Project #: 1003479

Project Name: LAND OF ST ANTHONY ORPHANAGE

DEVELOPMENT REVIEW BOARD MEETING – May 1, 2013

INTER-OFFICE MEMO

D SCREEN WALL
1/4" = 1'-0"

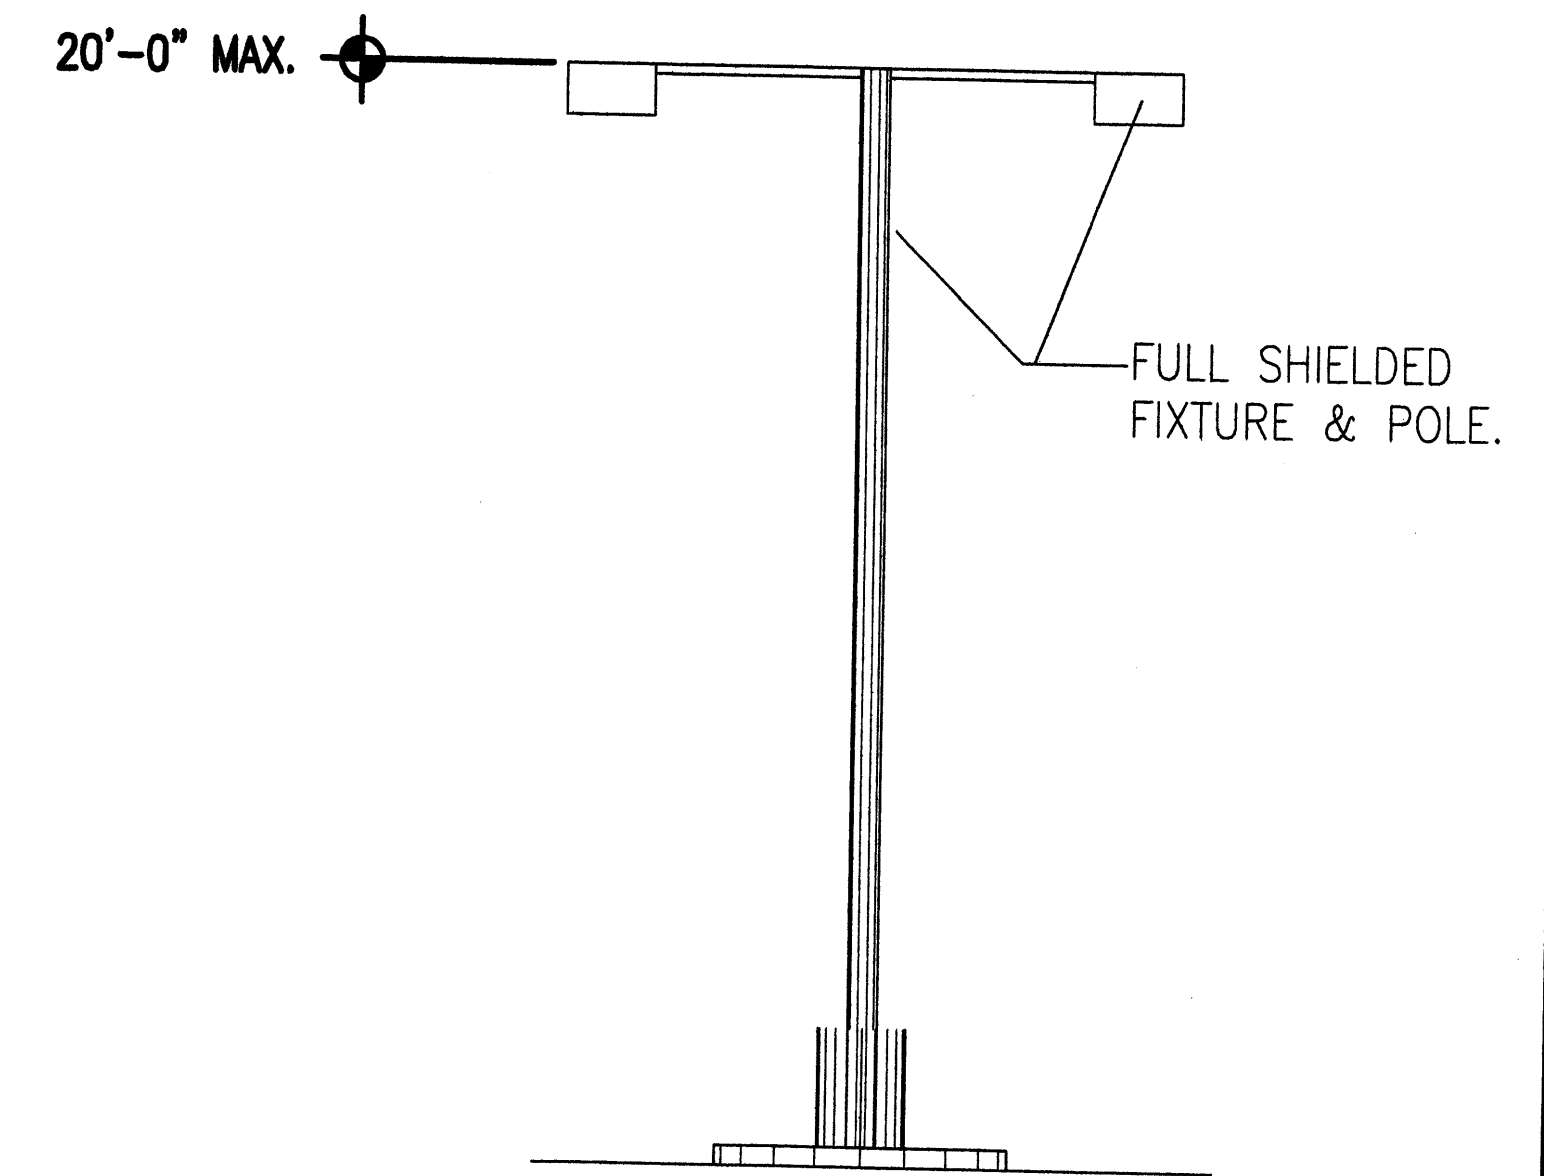
A wall detail showing material, height and color (at a minimum) shall be provided.

SHEET #
L2 OF L2

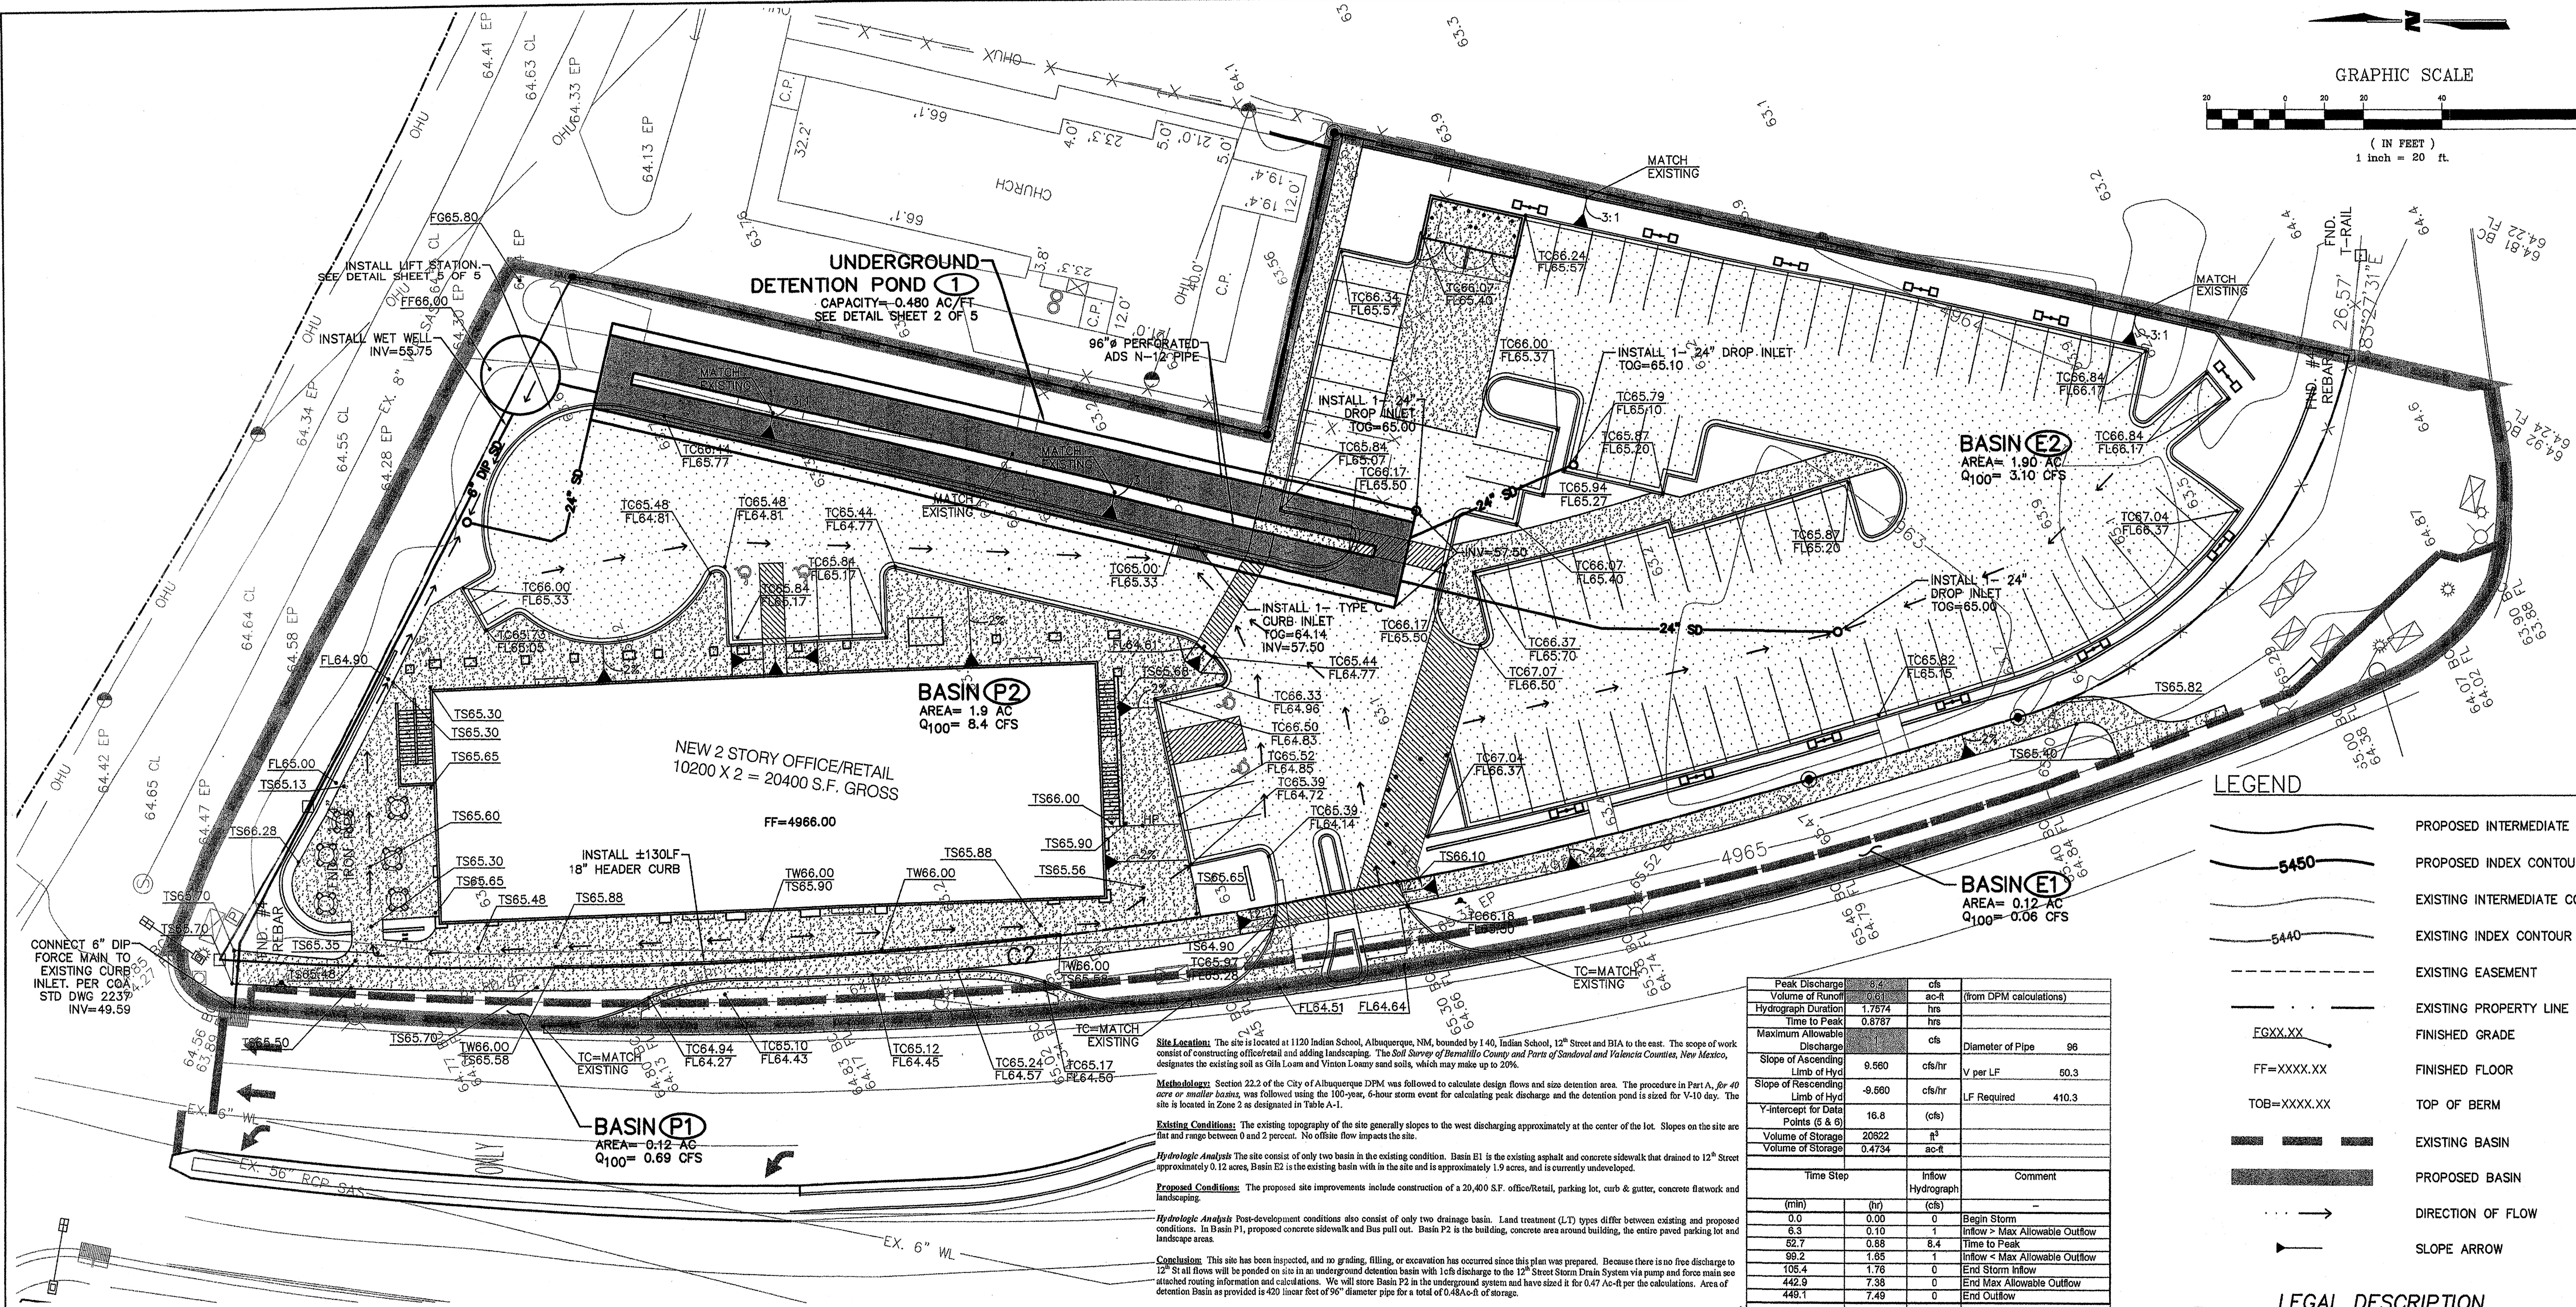
In “Landscape Project Notes”, please delete “crowned beds” as we have greater success with “swale” type beds that can collect rainwater rather than to shed water away from the plants.

On the Landscape Plan, box titled Landscape Maintenance, please add at the end of each sentence, “ and area within the right of way adjacent the lot” per City ordinance. It is important that the owner(s) understand and accept required responsibility for maintenance of the streetscape.

Please consult with local Landscape Architect regarding selection of Lirope Muscari in the Plan as my information states that it “prefers moist, fertile soils in part shade.” It may be considered to be “drought tolerant” but this is an extremely harsh, hot and dry site for plants preferring moisture and shade. Alternate plant selection can be considered from the Streetscapes Plant Master List or from the Albuquerque Water Authority Plant List.

The narrative on the landscape plan needs to be changed to indicate that 80% coverage with living, vegetative material shall be achieved.
